Martin J. Harvey B.Sc., C.Eng., MICE
Consultant Civil Engineer

97 Barnham Road, Eastergate - EG/107/17/DOC

I refer to the comments from Laura Gibbons, Engineer (Drainage & Coastal), at Arun District Council dated 3 May 2018 and respond as follows:

Number
S17-03-01 G

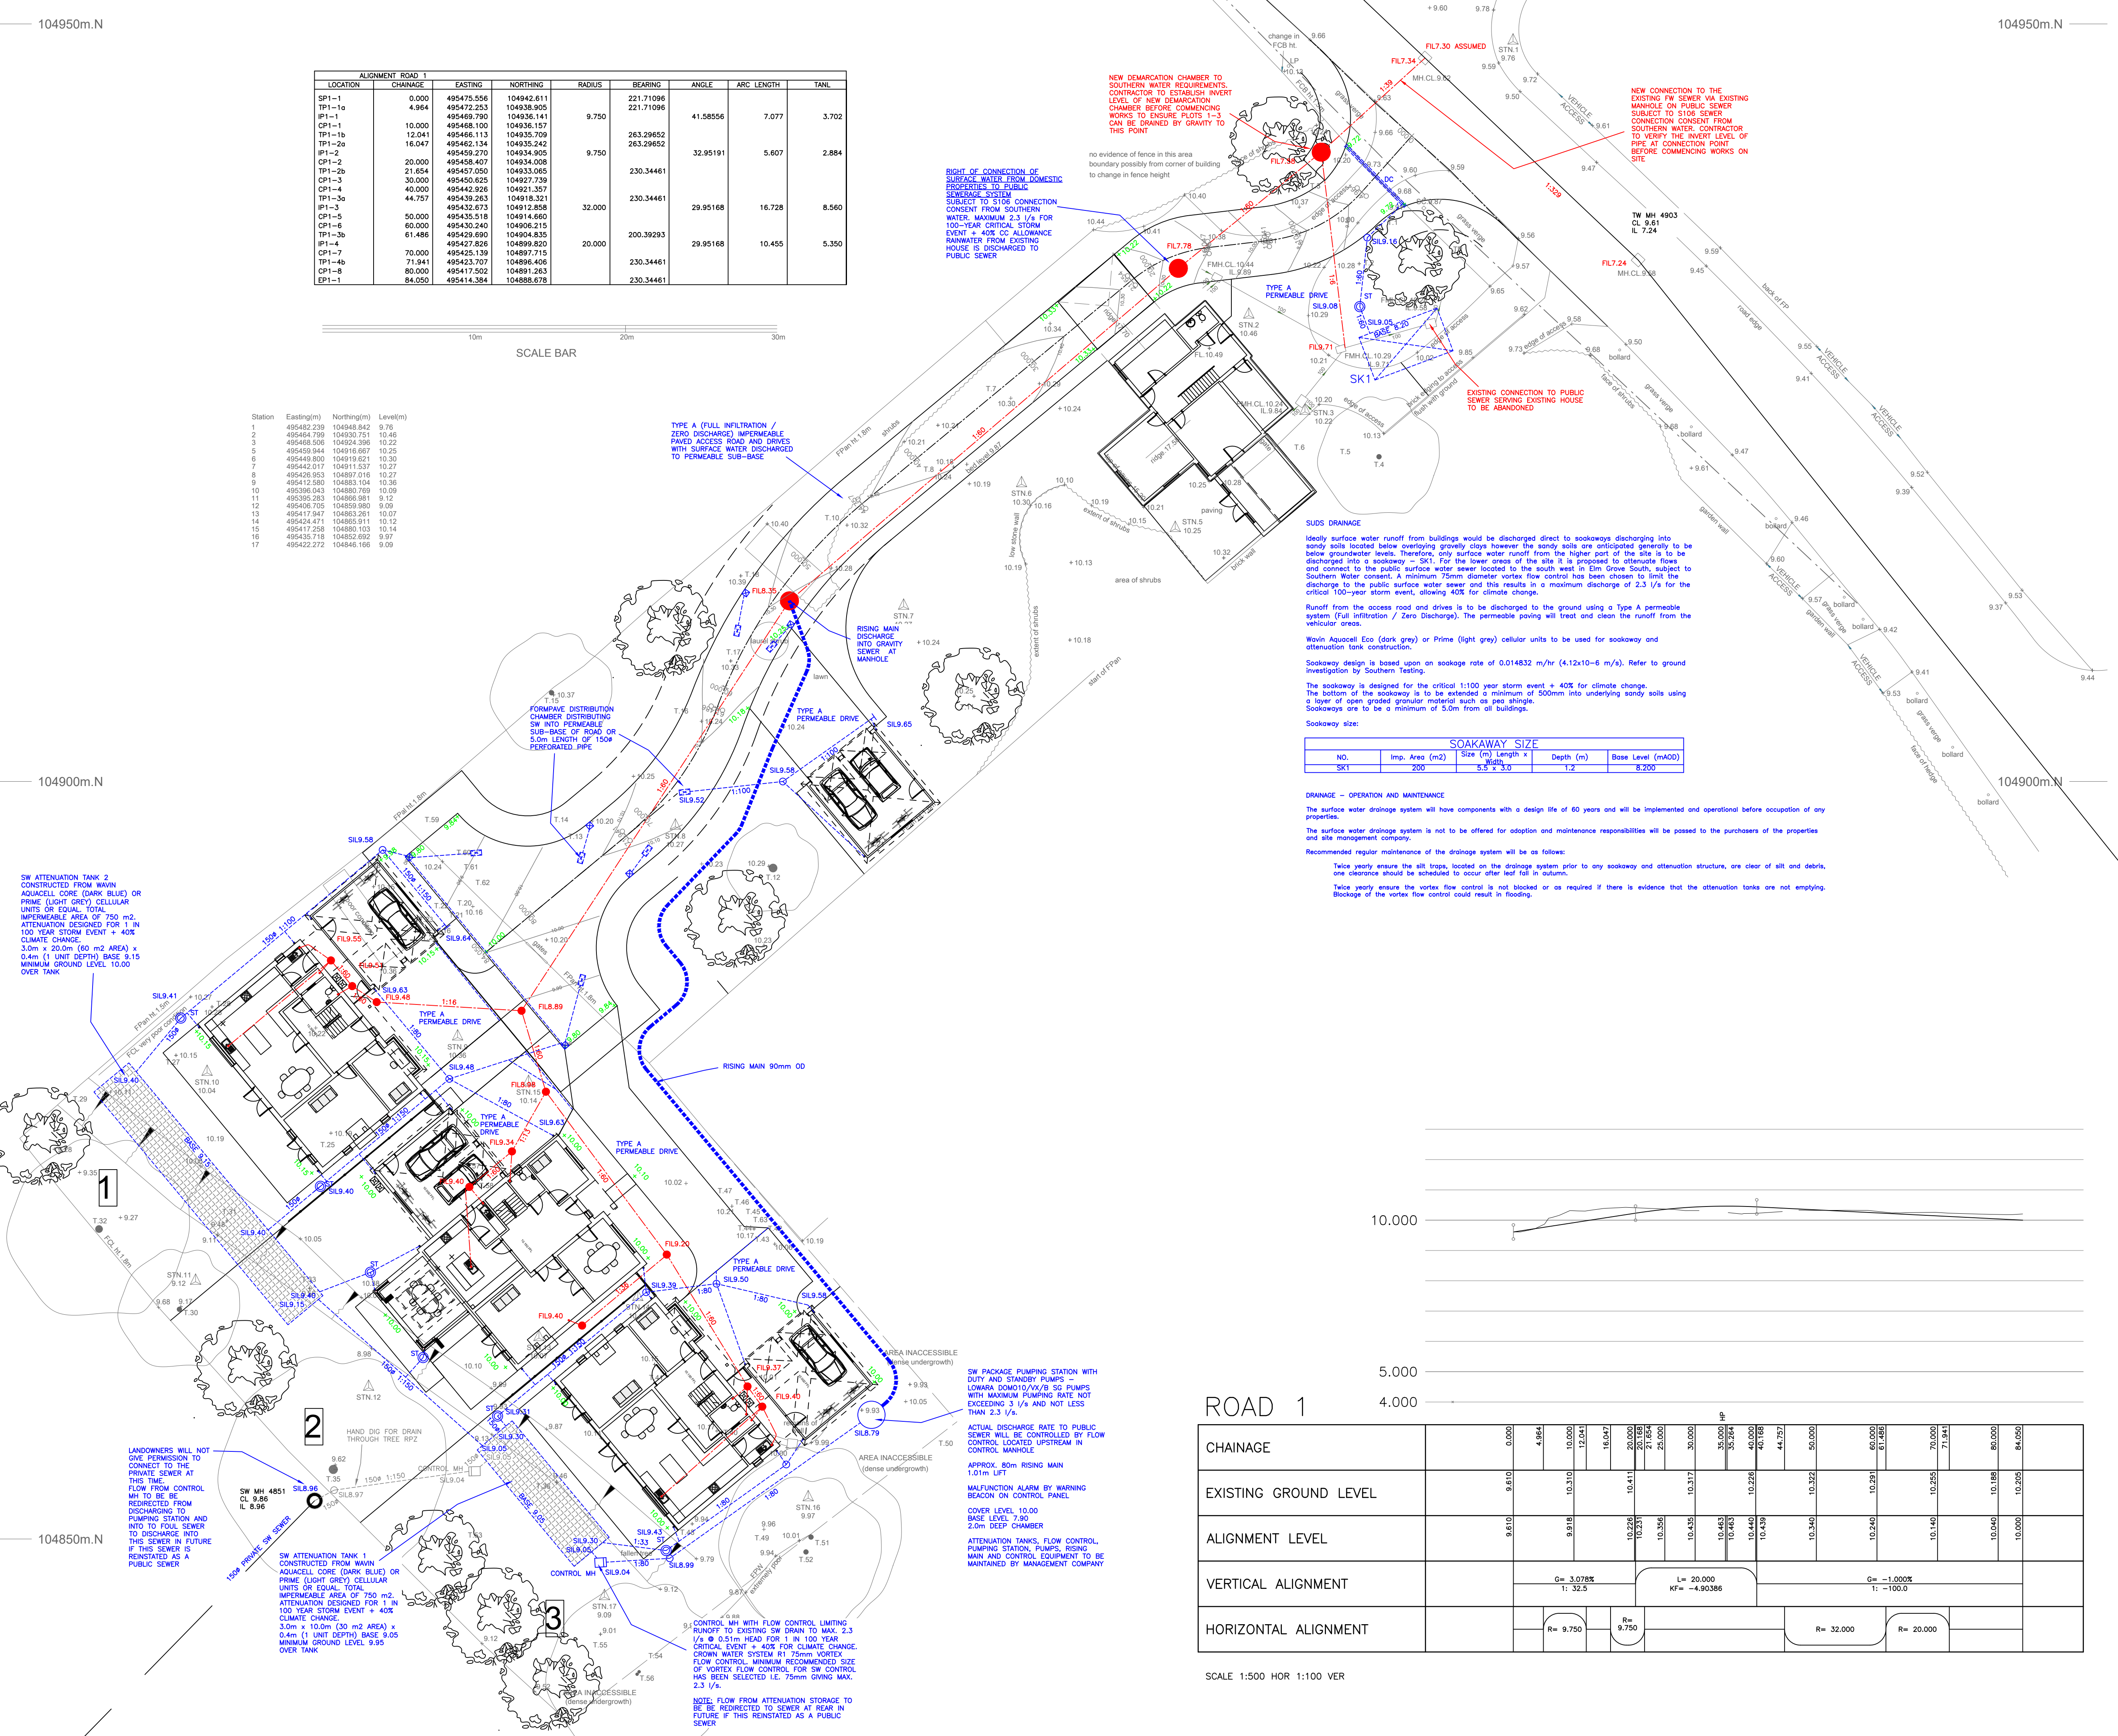
- *Thrust blocks need to be provided on the rising main.*
The rising main has been constructed in MDPE continuous coiled pipe without separate bends and using self anchoring joints at the ends and therefore thrust blocks are not required.

- *Where the depth of the rising main is less than 0.9m we require the pipe to have a concrete bed and surround or concrete protection slab to be provided.*
The rising main is not adopted and laid in landscaped areas and Building Regulations only require protection when cover is less than 600mm for thermoplastic pipes and I am advised that at least this depth of cover is provided throughout. The installation has been approved by Building Control.

- *A discharge manhole needs to be provided a minimum of 10m from the connection to the foul water main. With a length of gravity main in between at a suitable gradient, with a vertical back drop if greater fall is required.*
There is a requirement in Sewers For Adoption for a separate manhole and a short section of gravity sewer to be constructed at the end of a rising main to enable the flow to gravitate to a manhole on the public sewer. The rising main discharges into a manhole on the private gravity drainage system and this manhole is in excess of 10m from the public sewer. The installation has been approved by Building Control.
